**FINAL DRAINAGE REPORT
FOR
LATIGO TRAILS FILING NO. 10
AND
ADDENDUM TO MASTER DEVELOPMENT/
PRELIMINARY DRAINAGE PLAN
FOR LATIGO TRAILS,
EL PASO COUNTY, COLORADO**

September 2021

Add text:
PCD File No.:
SF2136

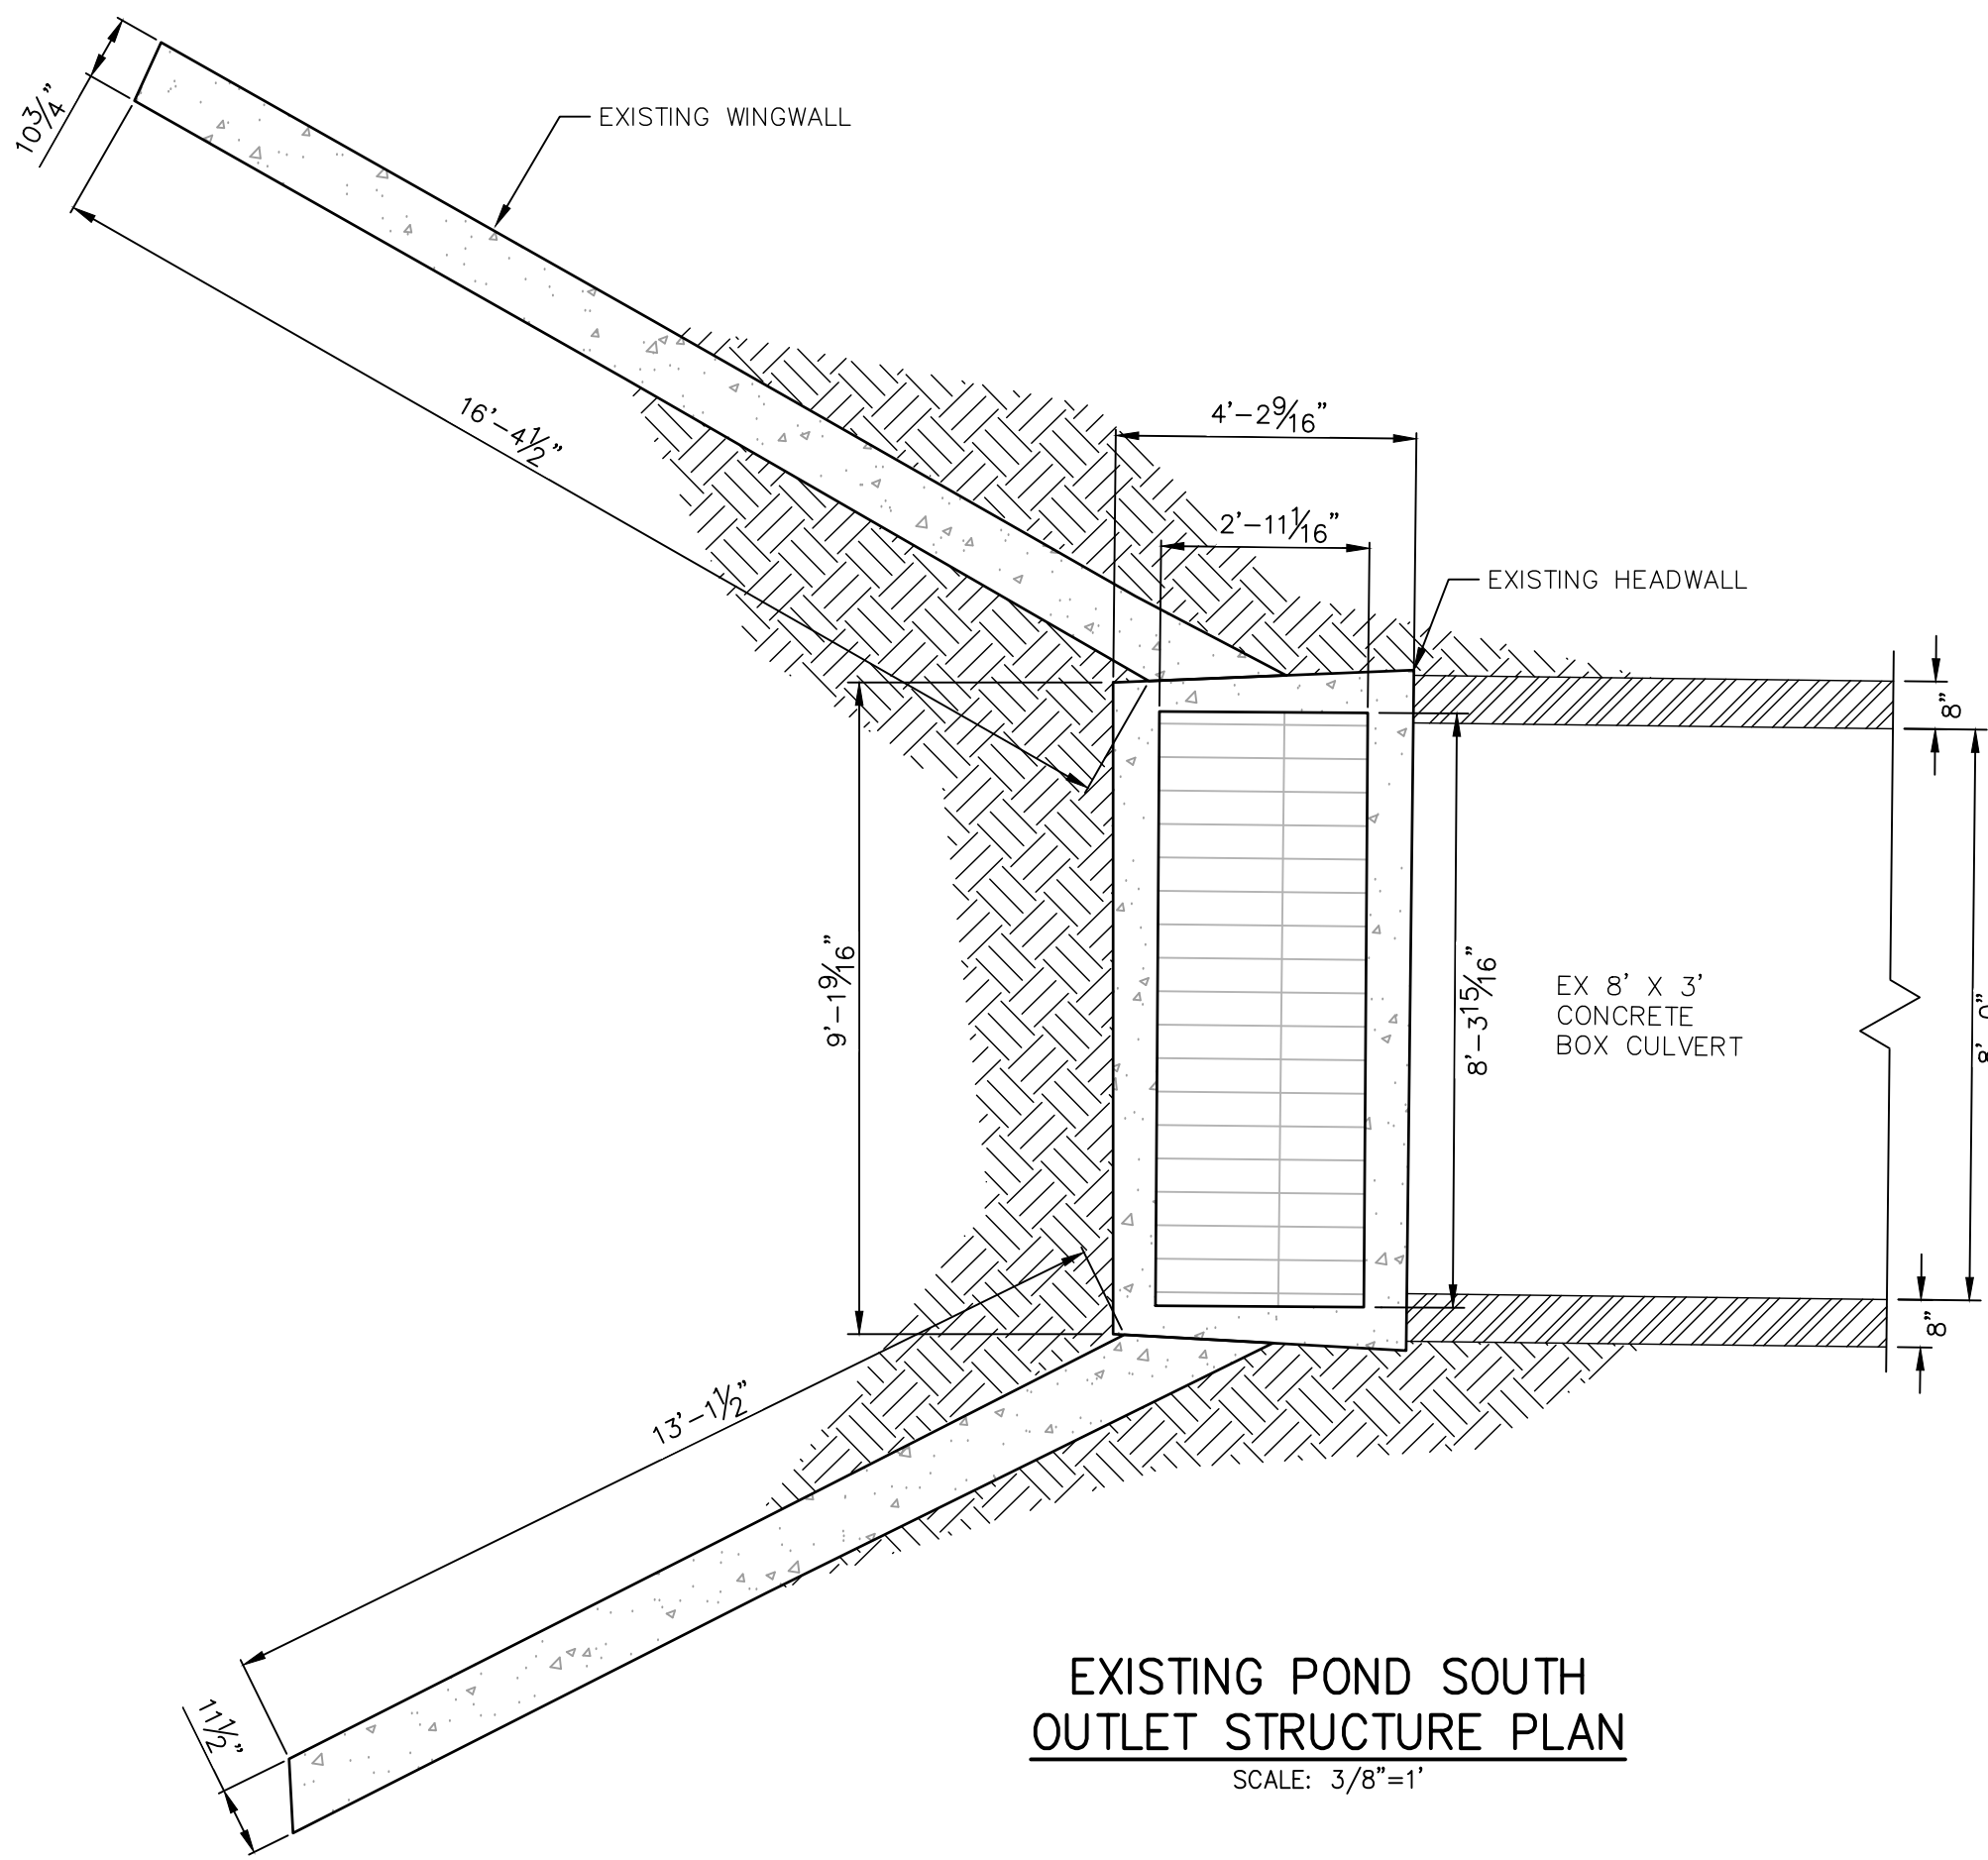
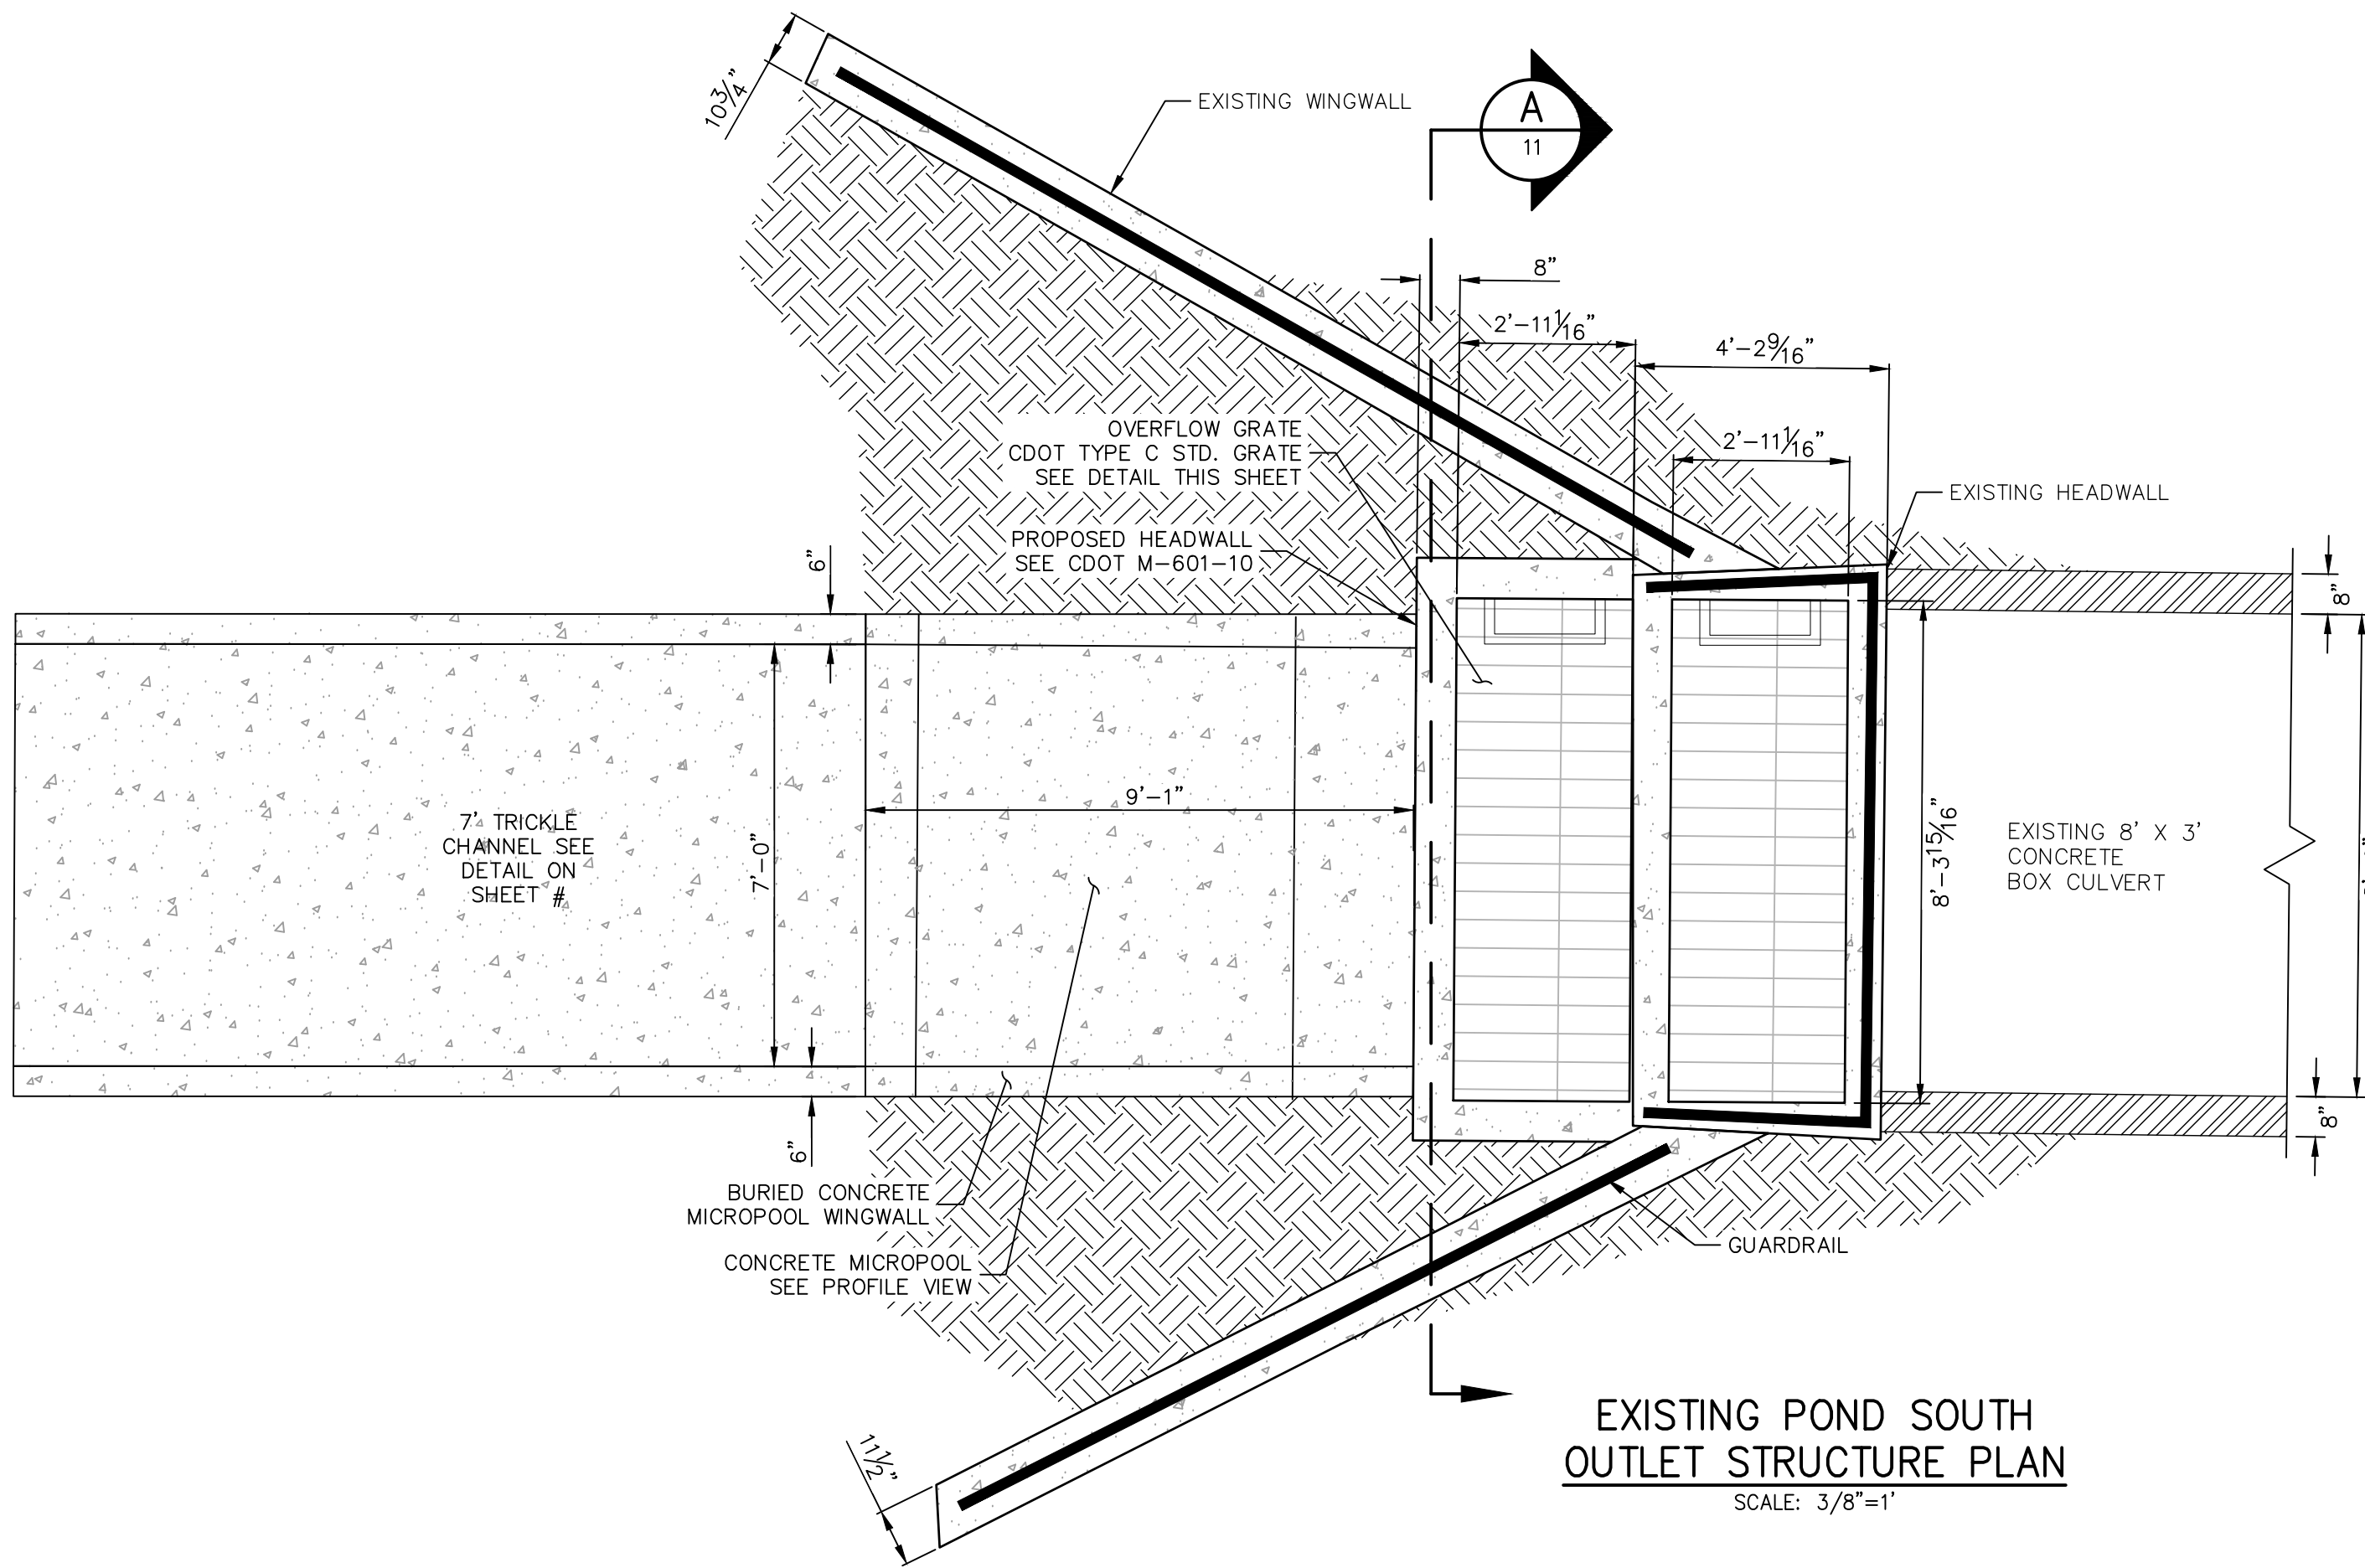
Clarify. Is the needed 10.3 ac-ft volume associated with the existing condition or w/ filing 10 development or ultimate condition (which includes Filing 12)?

The outfall needs to be analyzed with this FDR. Update last sentence to provide a summarize the results. Is the conveyance downstream of the pond hydraulically adequate?
